Application for Approval of Reserved Matters Following Outline Approval

Development: Approval of reserved matters following outline consent AL/178/22/OUT for appearance, landscaping, layout and scale for 89 No dwellings with open space and associated works (resubmission following AL/50/24/RES). This application is a Departure from the Development Plan and is in CIL Zone 3 and is CIL Liable as new dwellings.

Location: Land Rear Of Meadow Way Including 24 Meadow Way Westergate

Elevation Code: B1
1316 ft² 122.21 m²
Date: Jan 2023
EG_CES2_DM.2
Rev: A

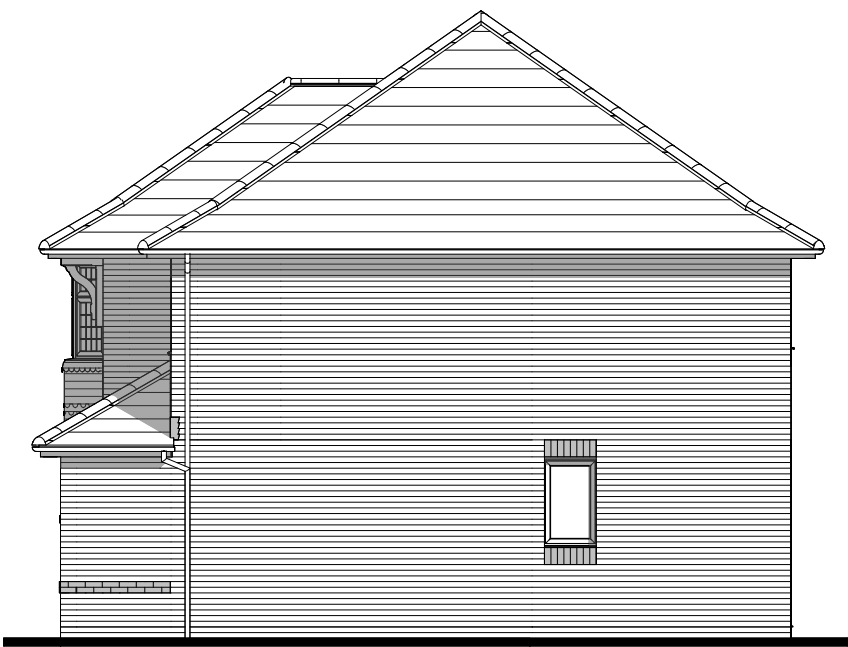
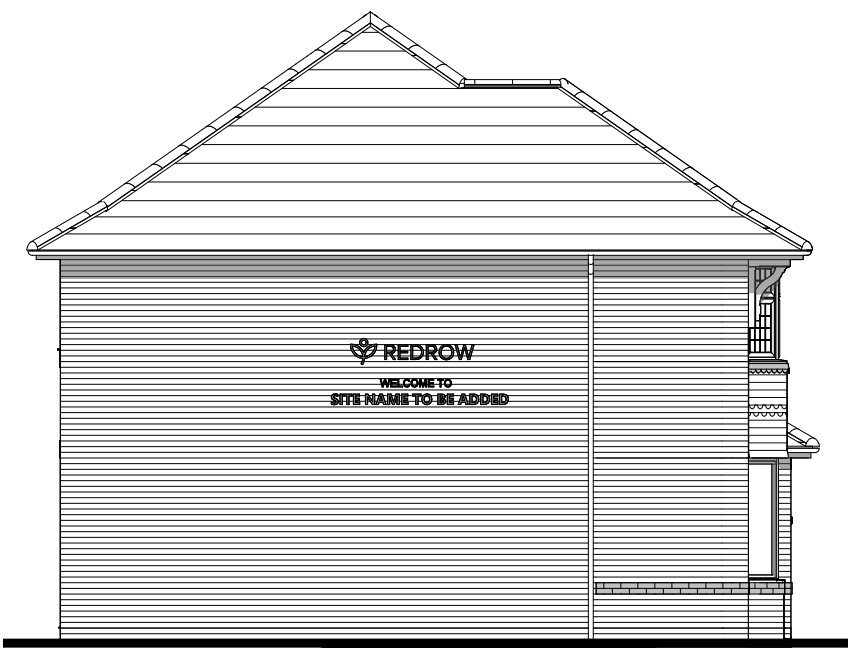
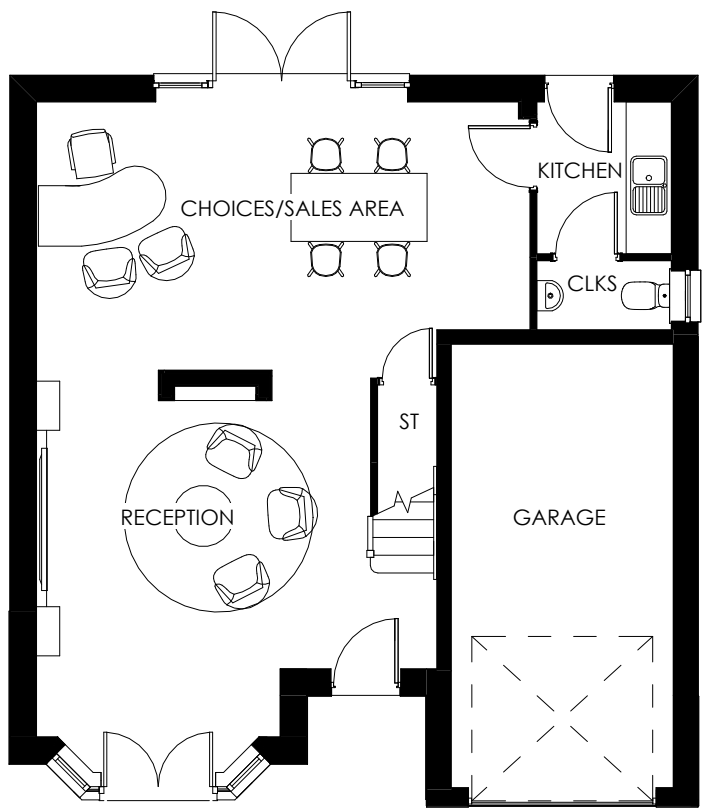
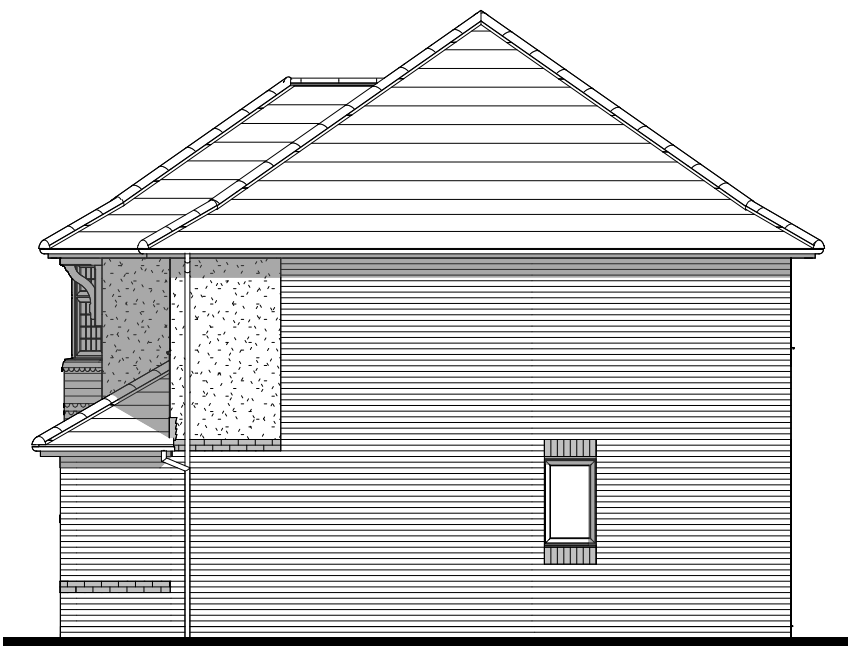
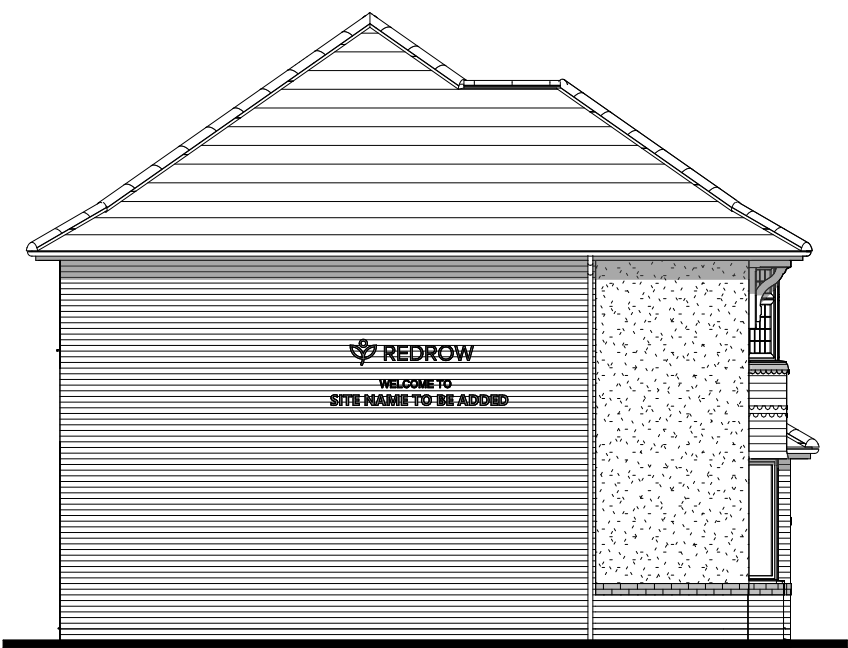
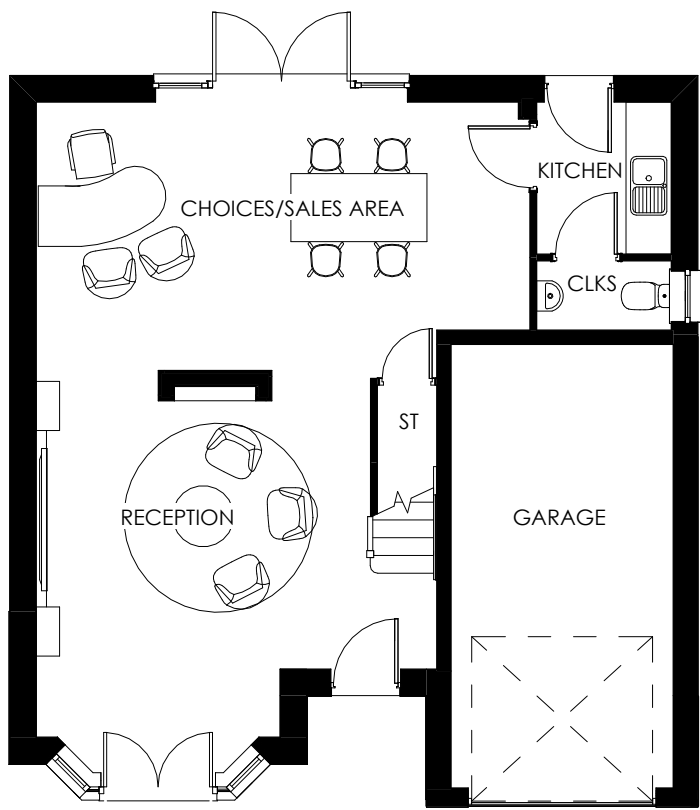
ON Plan EG_CES2_DM.2, please provide a first floor plan and the plot numbers.
